**Peter McManus - Modification Request for the University of Sydney Abercrombie Precinct
Redevelopment: Application Number: MP07_0158 MOD 3**

***Regarding: Modification Request for the University of Sydney Abercrombie
Precinct Redevelopment: Application Number: MP07_0158 MOD 3***

Ground Floor Plan
1:200@A1
11.10.13
4001_DA02-D

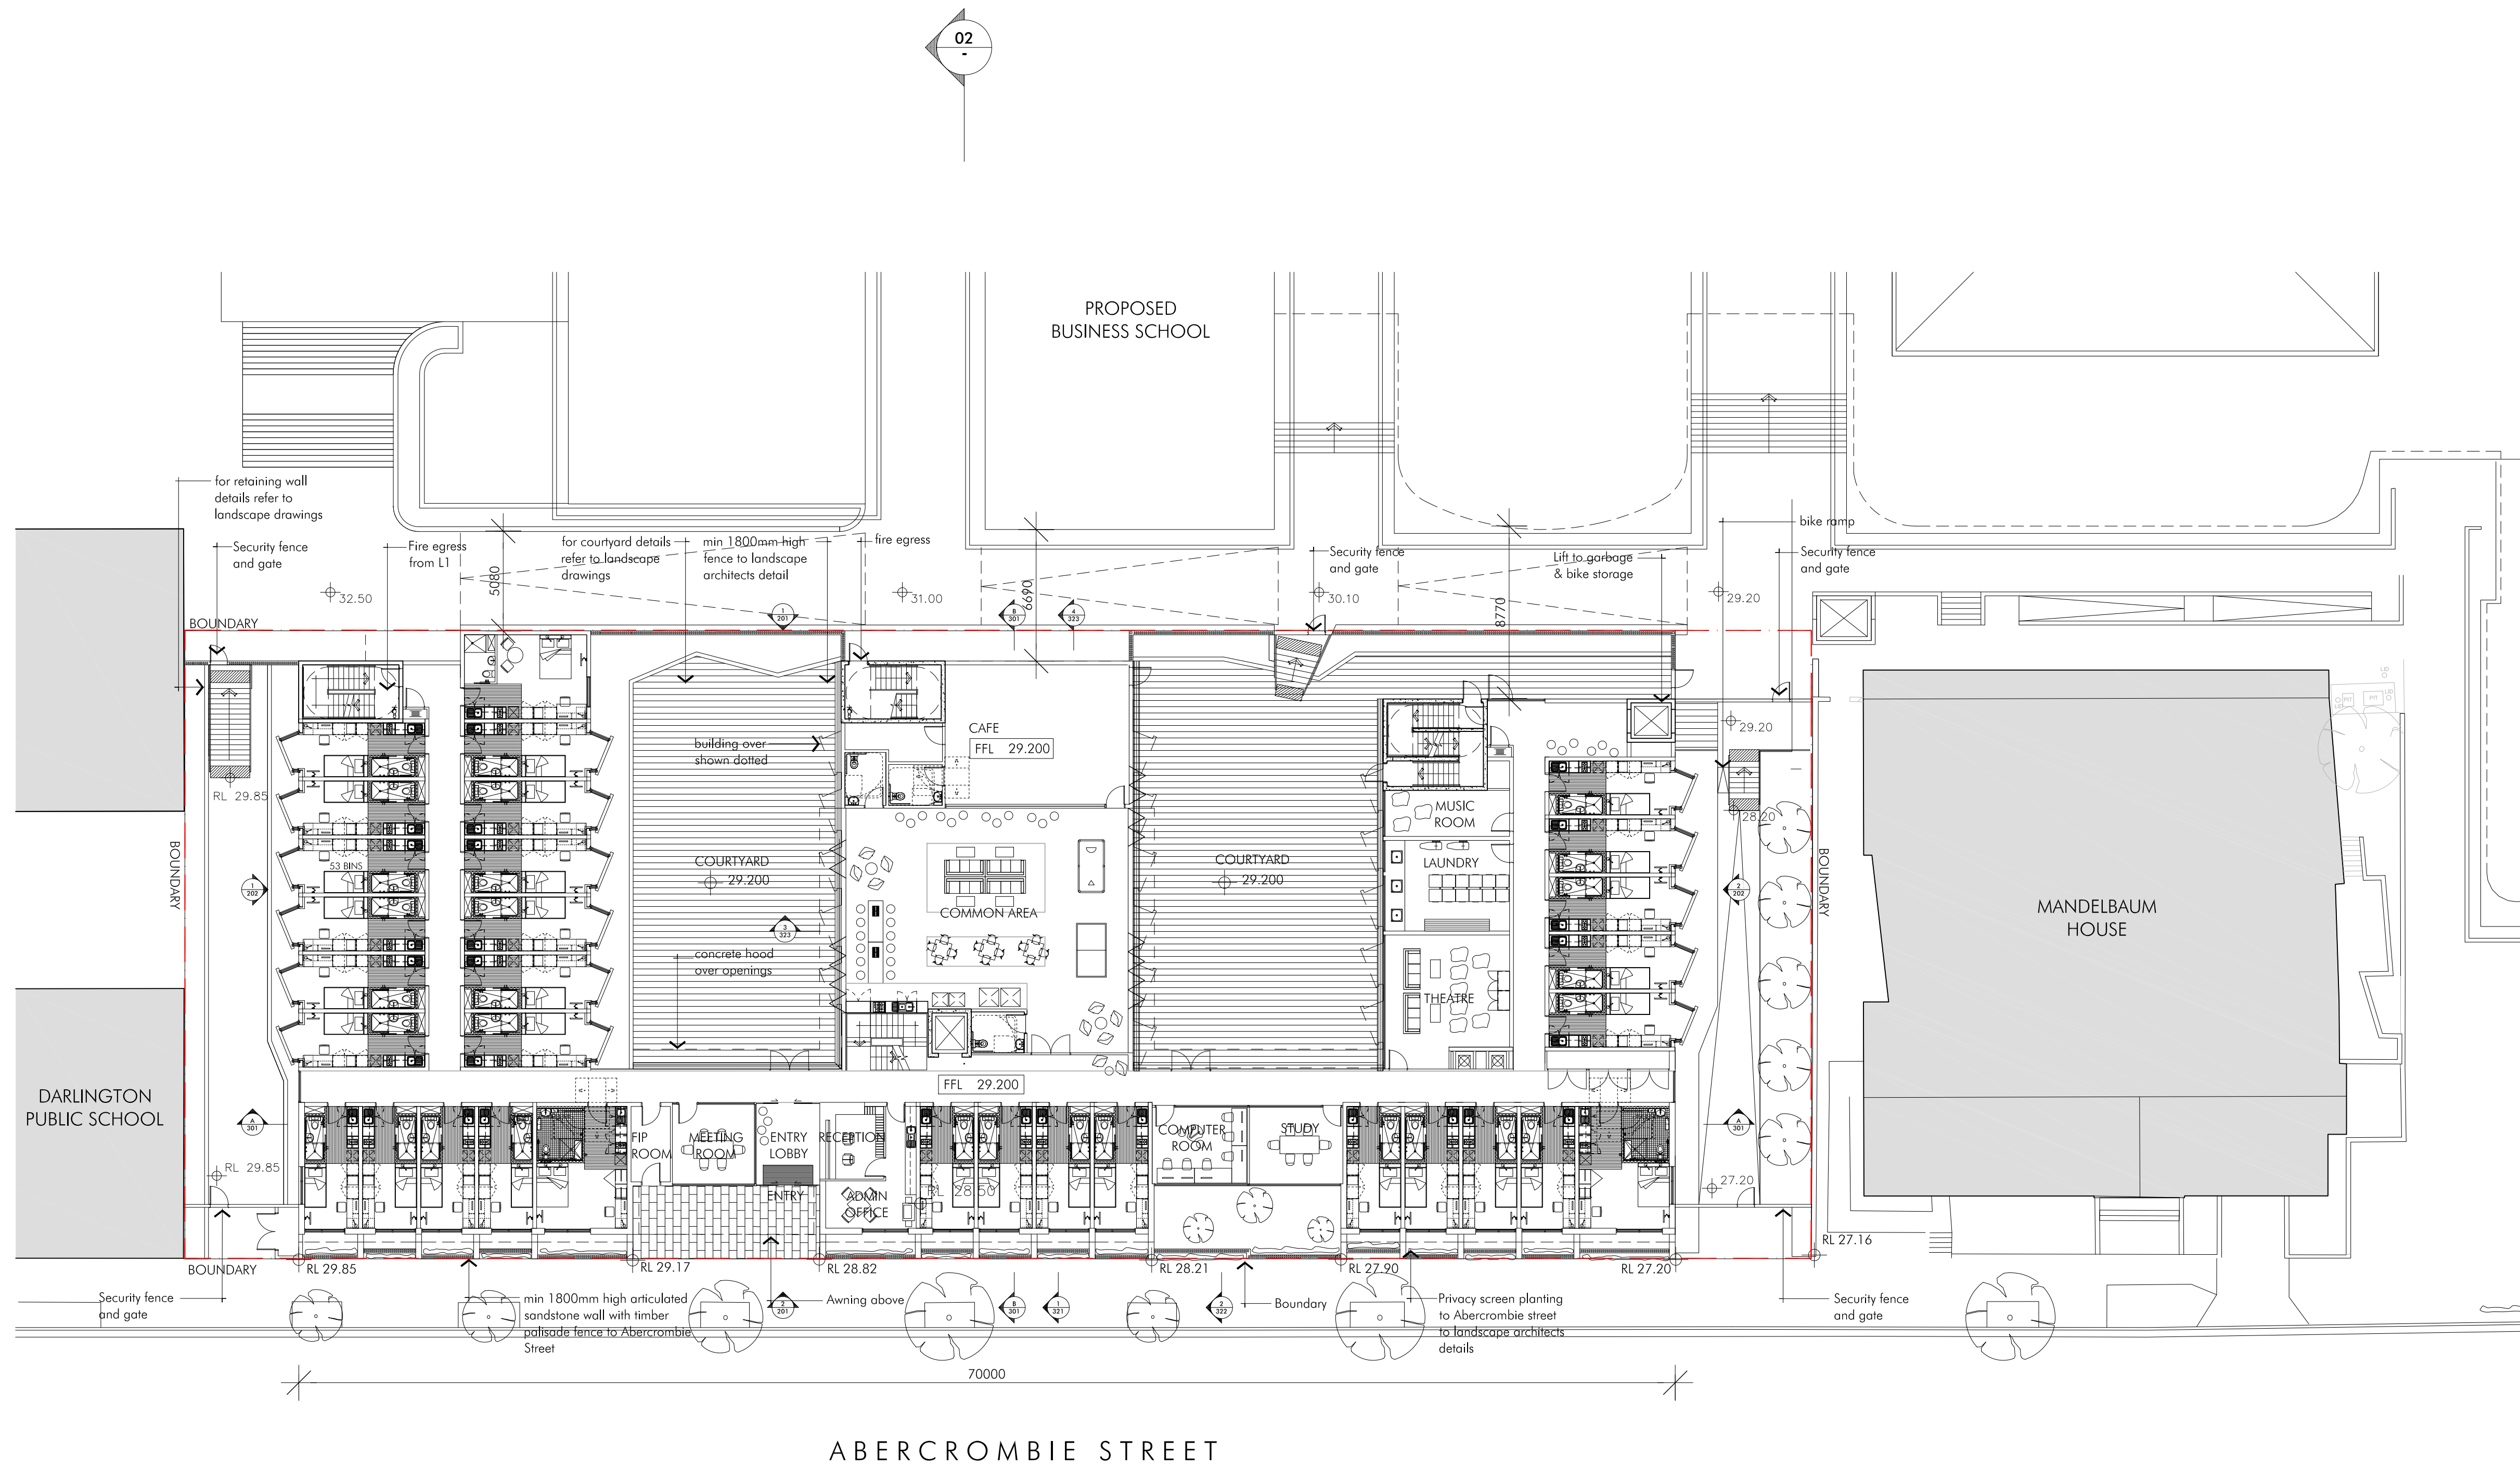
Whereas the previously approved DA set the building facades of the upper floors back from the street this new proposal moves the buildings substantially closer to the street and the upper floors in line with the footpath thus encroaching unacceptably on the existing street scape. As demonstrated by the Shadow Diagrams this means that the residential dwellings opposite will now be darkened from approximately 3pm in the afternoon. Additionally because the new building is substantially taller than surrounding buildings it will dominate the street and will be detrimental to existing heritage ambience of the area. By decreasing the space between it and the street the potential for green space that would soften the facade it also virtually negated.

I request the the University adhere to the original proposal it made to the residents of Darlington a align the facade of the new buildings with that of Mandelbaum House.
